## **MERITON APARTMENTS**

# **LOT 101-102, 52 WALKER STREET RHODES**

## **ACCESSIBILITY REVIEW**

1<sup>st</sup> June 2010

DRAWING TITLE:  
**ADAPTABLE**

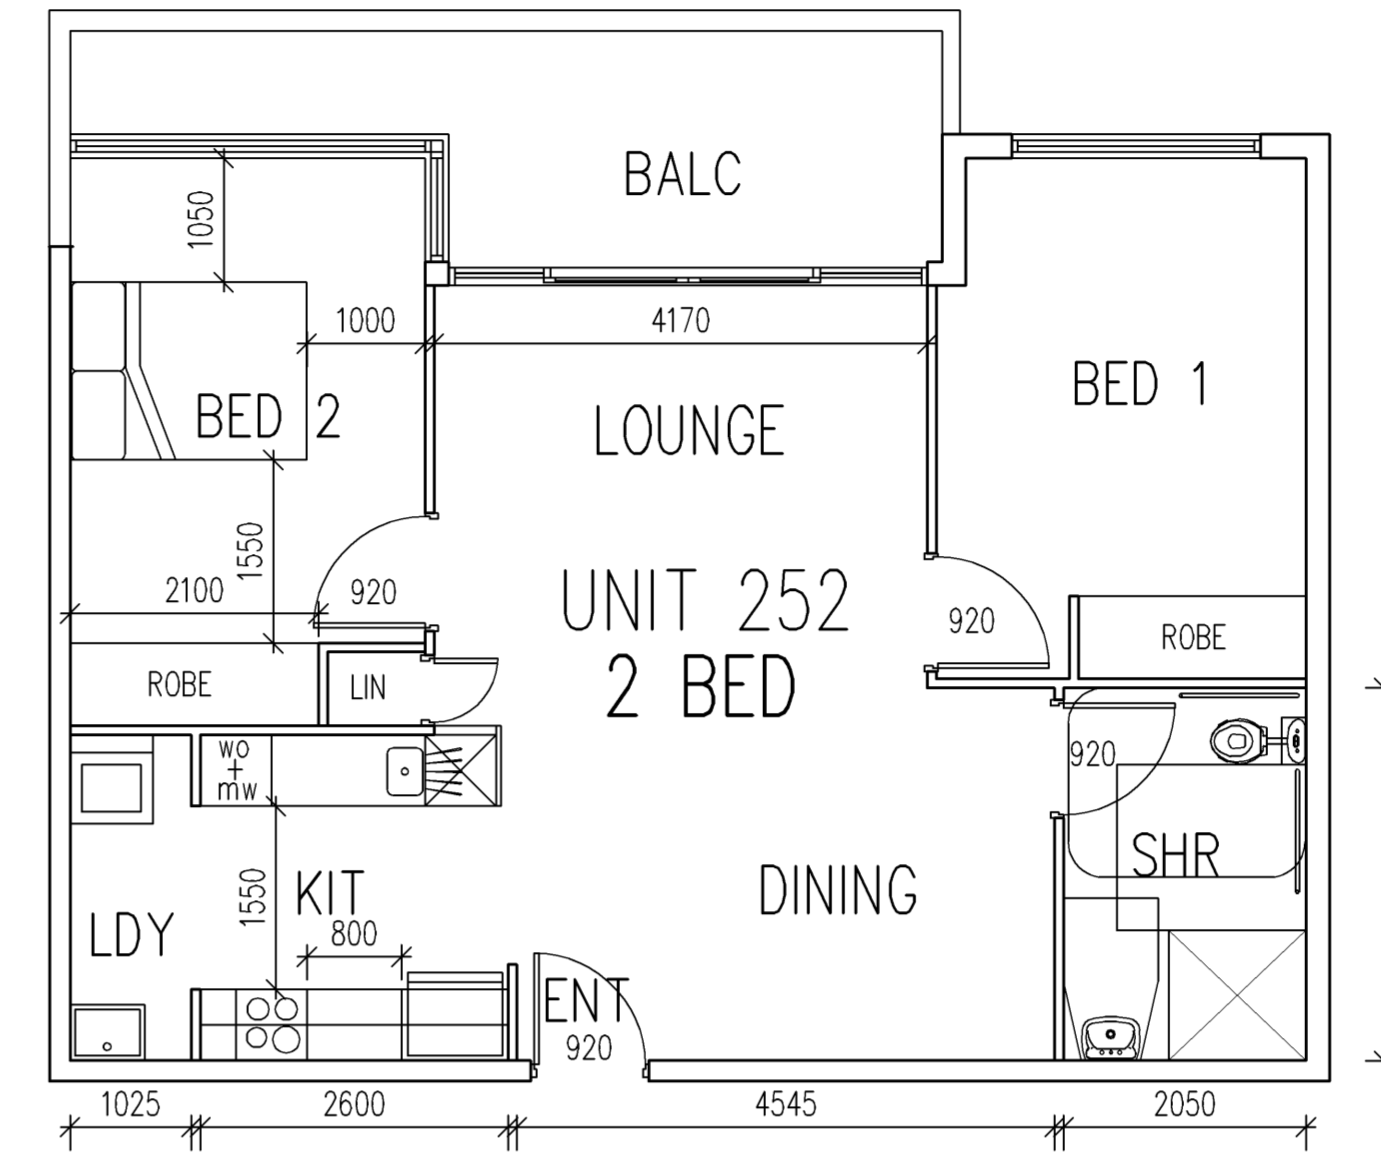
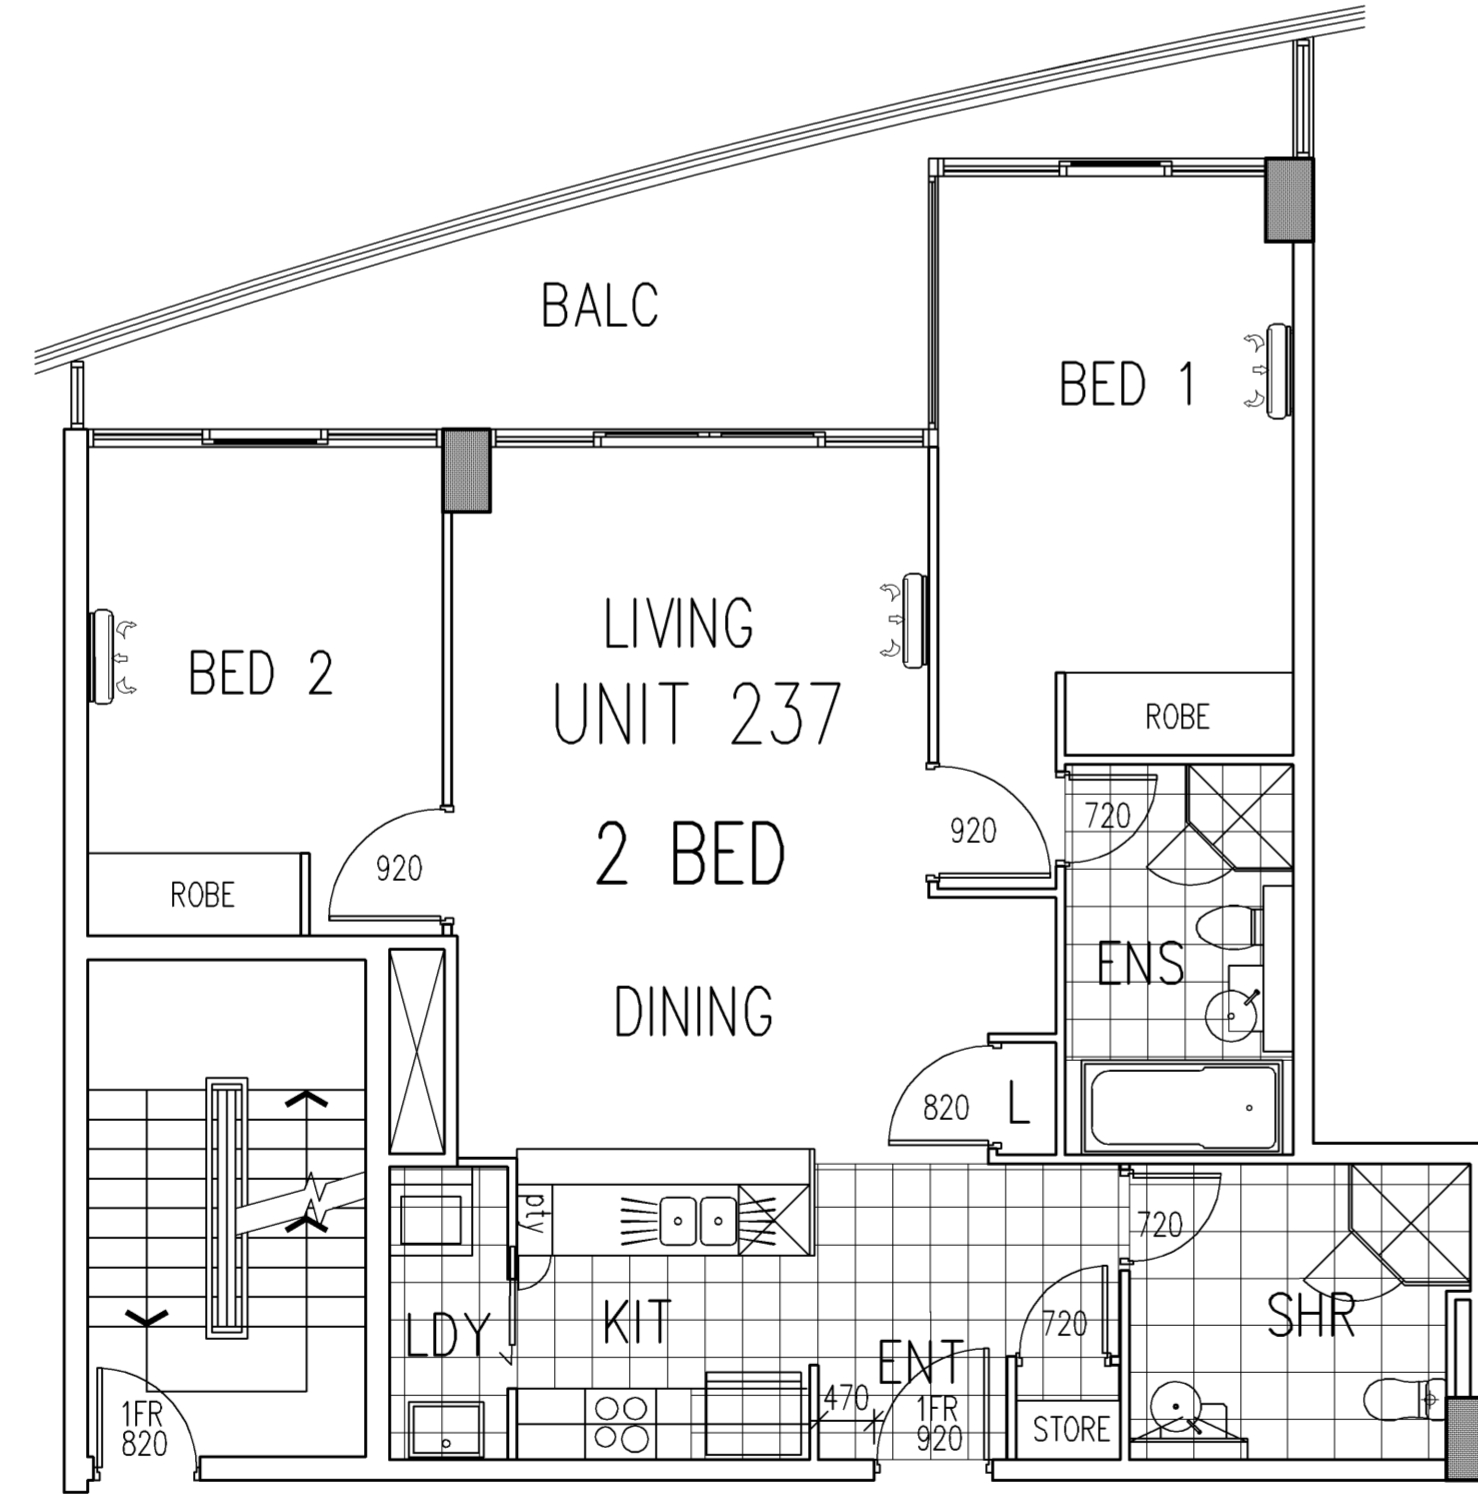
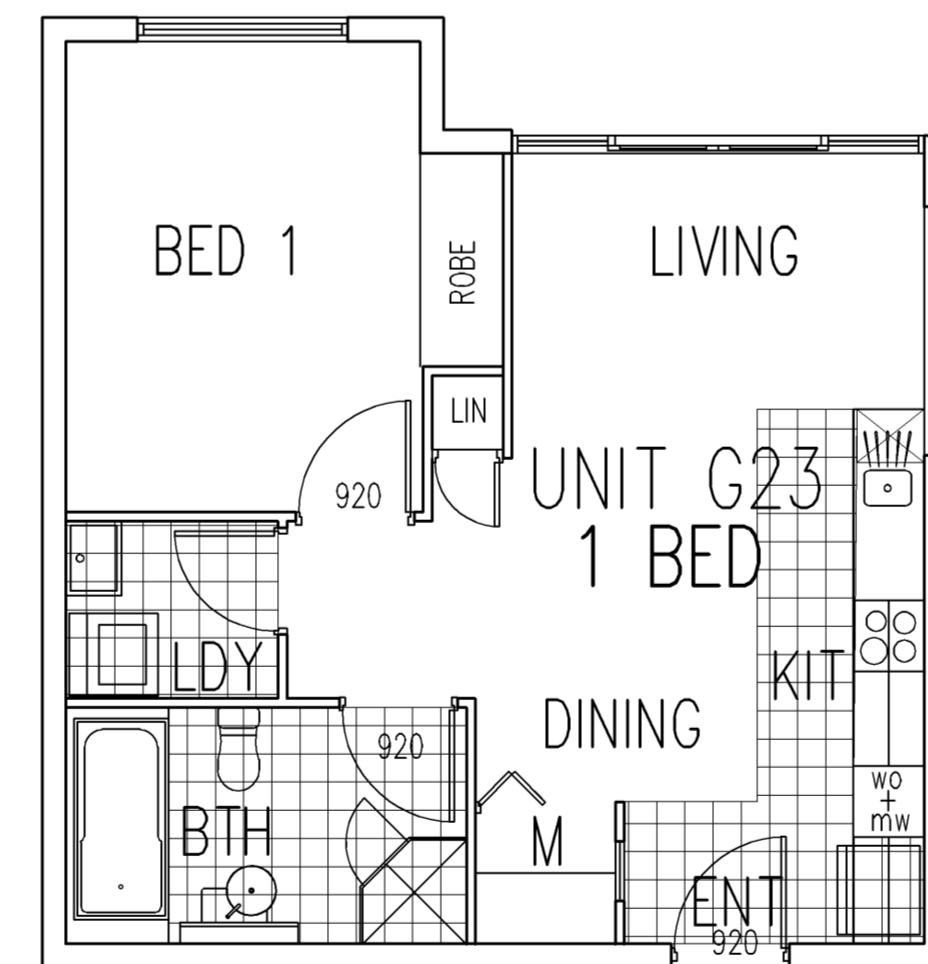
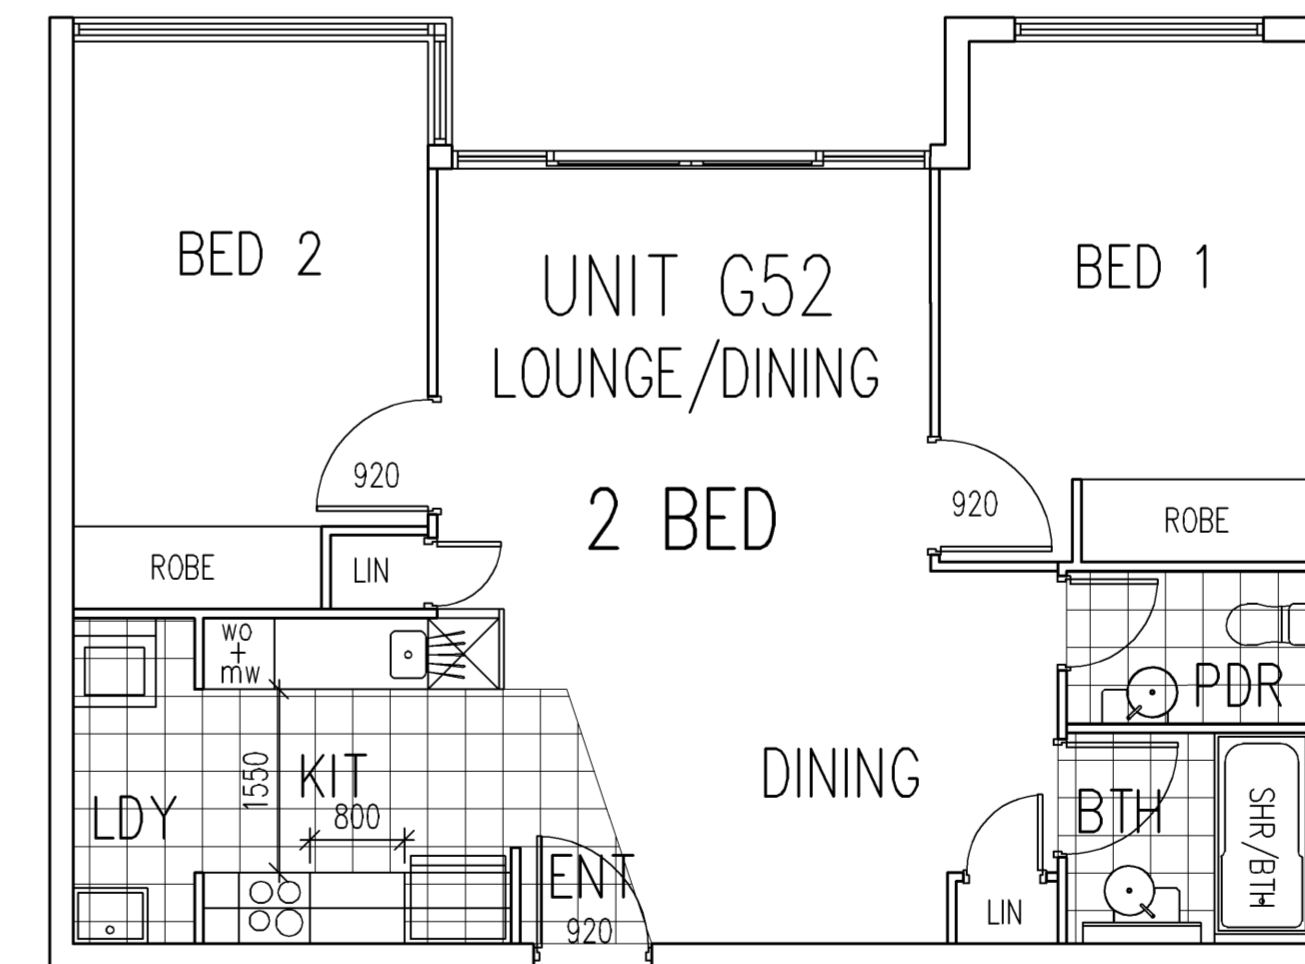
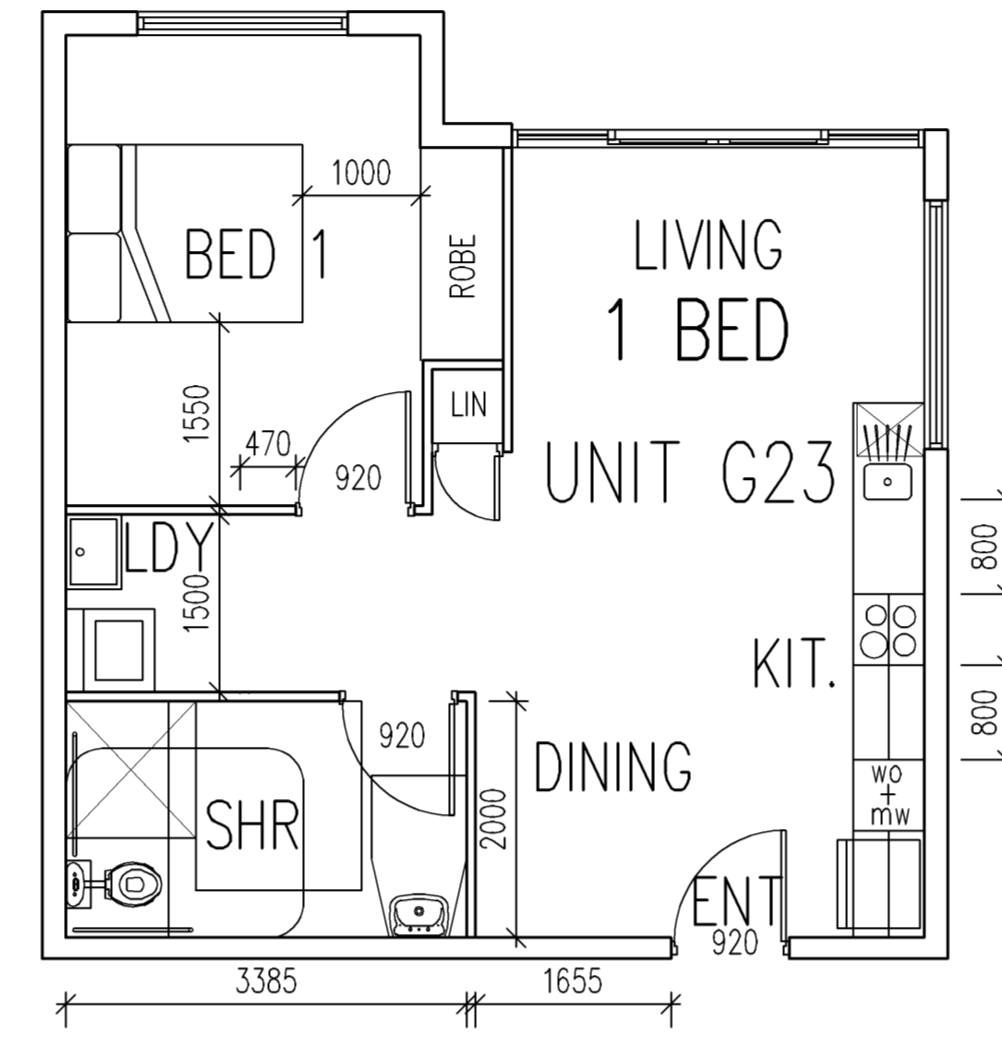
The kitchen island in blocks A and C can be easily moved to achieve 1550mm clear width. The kitchens in Blocks B and D have appropriate bench space adjacent wall mounted oven, sink and cook top.

*Recommendations:*

- (i) The kitchen in Block A and C needs wall mounted oven and cook top in place pre-adaptation
- (ii) The laundry area in Block A and C to have a circulation area in front of the laundry appliances of 1550mm in diameter.
